West Burton Solar Project

Without Prejudice Archaeological Mitigation WSI Revision A

Prepared by Lanpro
~~February~~April 2024

PINS Ref: EN010132
Document reference: ~~EX4~~EX5/WB8.2.9 A

Figure 4. Archaeological mitigation areas within West Burton 3

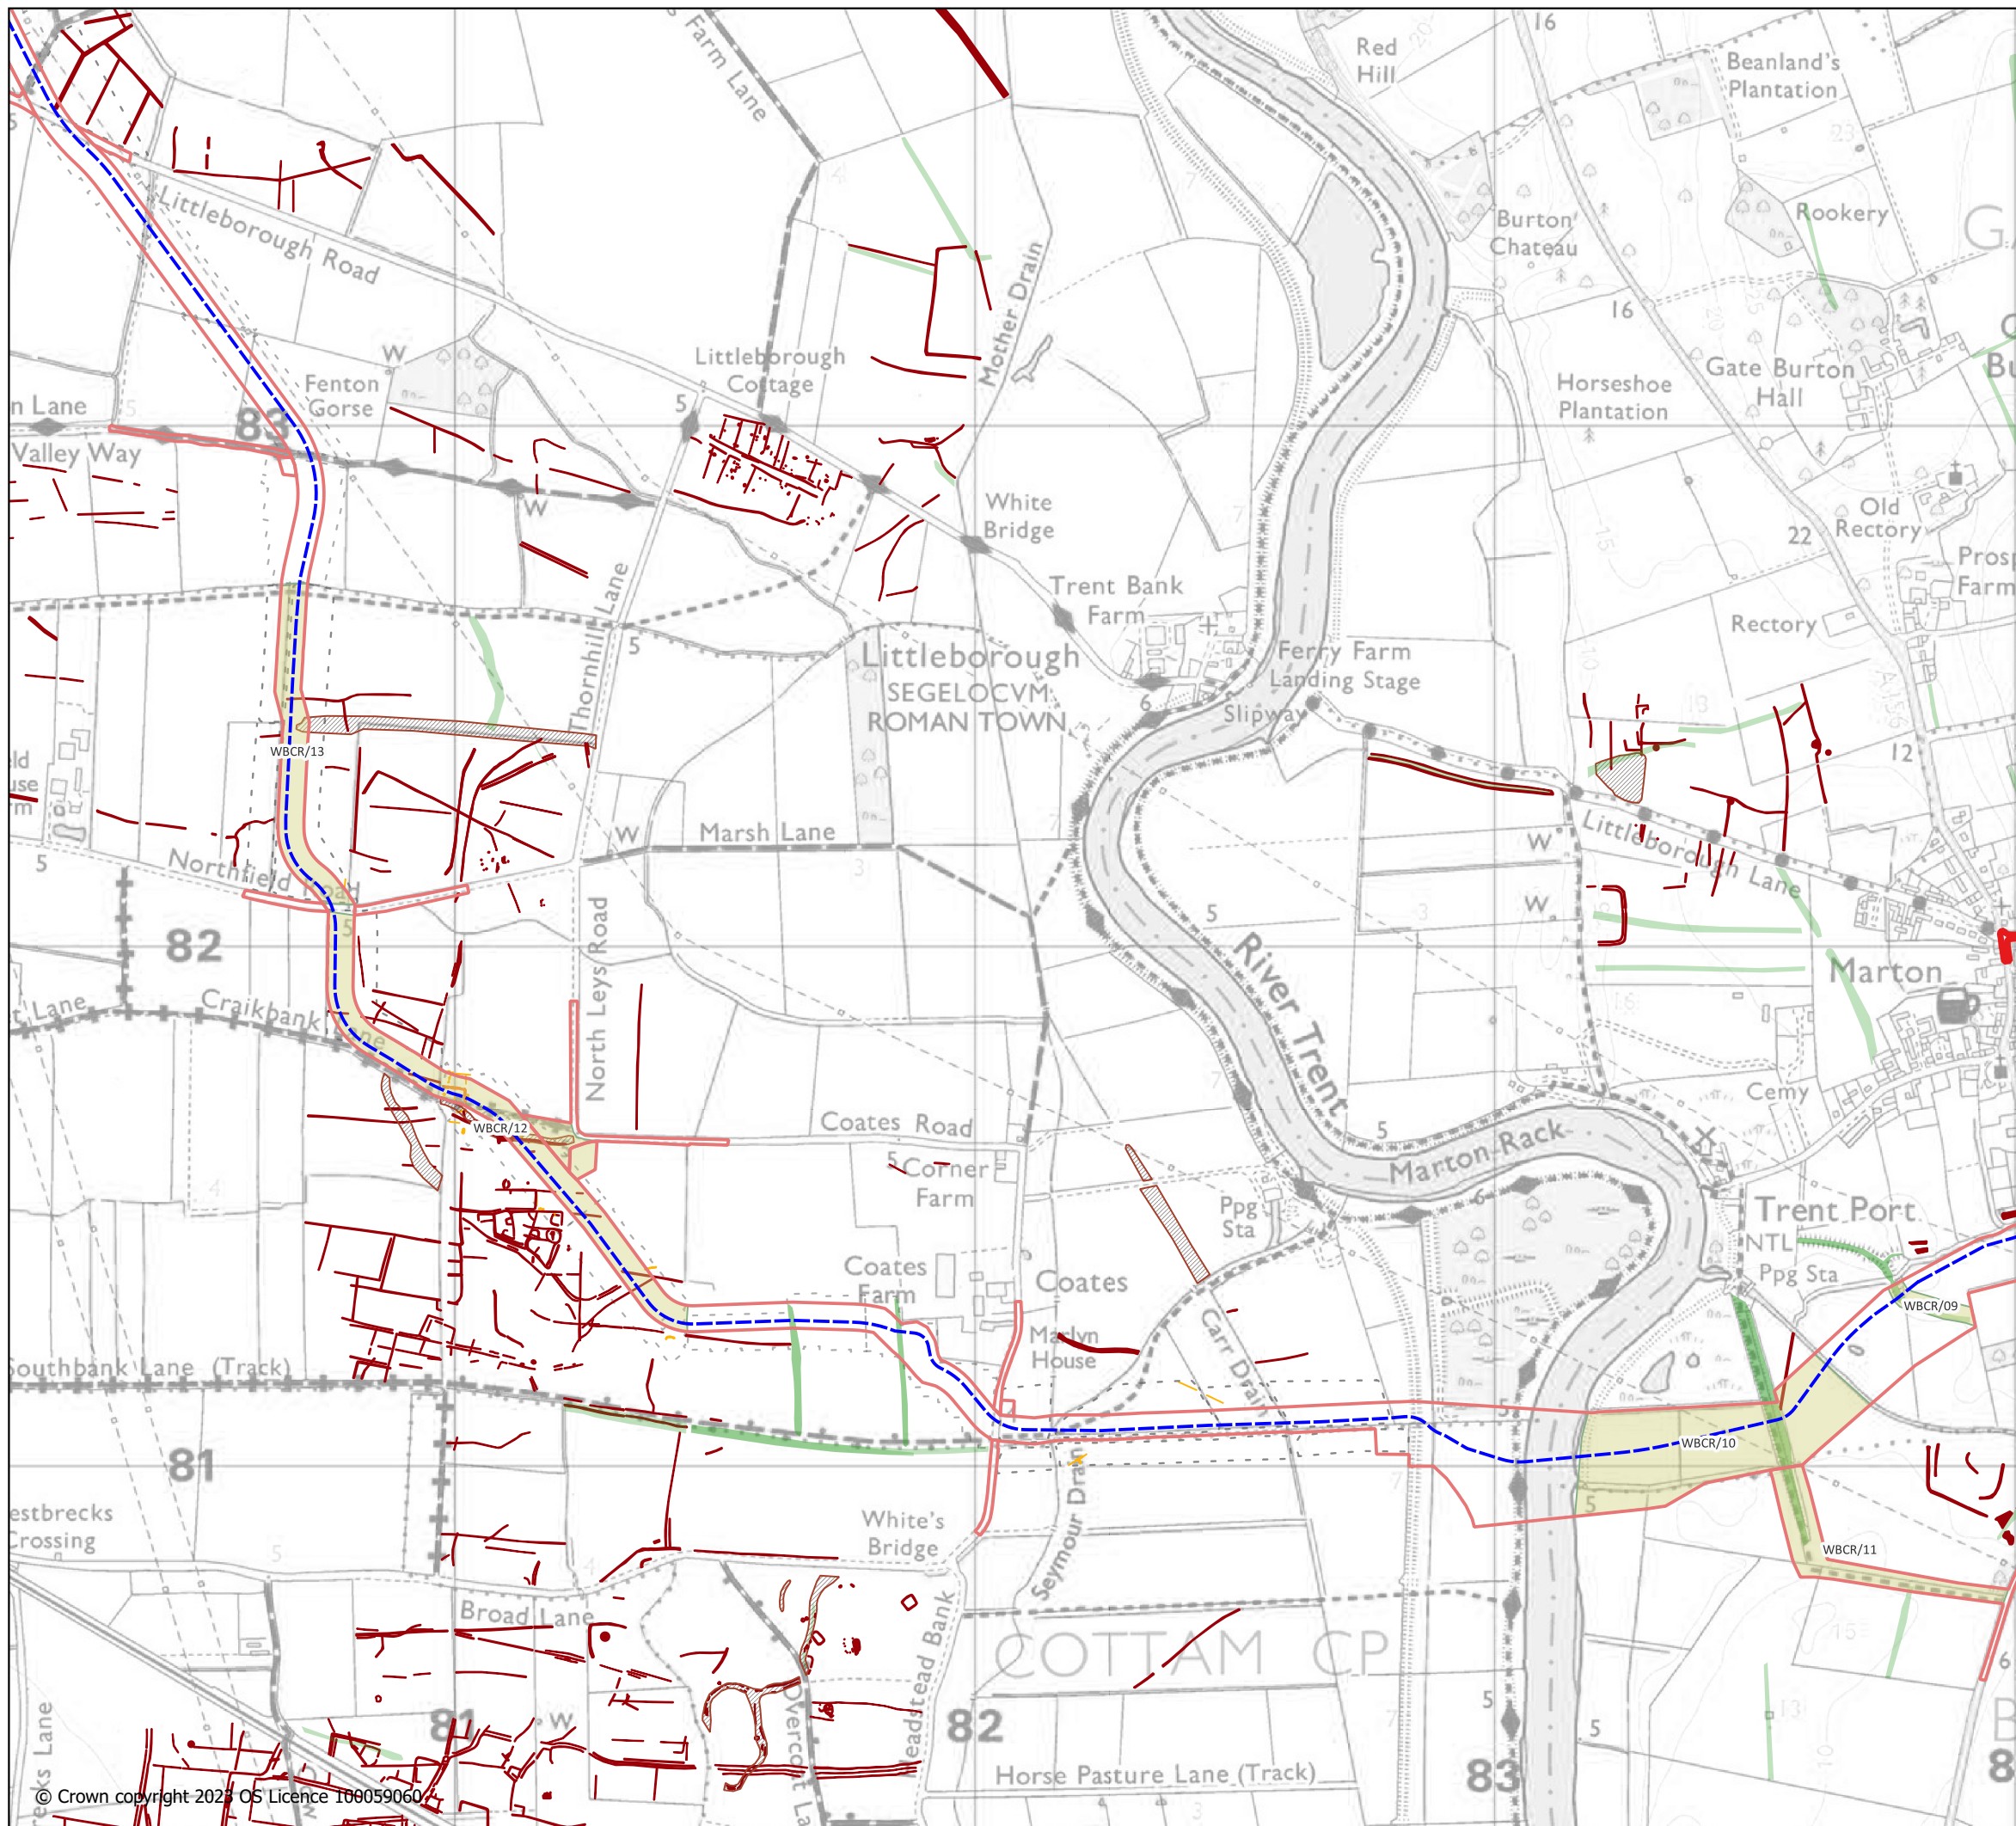
Figure Reference	Page	Description of Changes	Reason for Revision
Figure 4	55	Term watching brief changed to archaeological monitoring	Response to comments from LCC and NCC
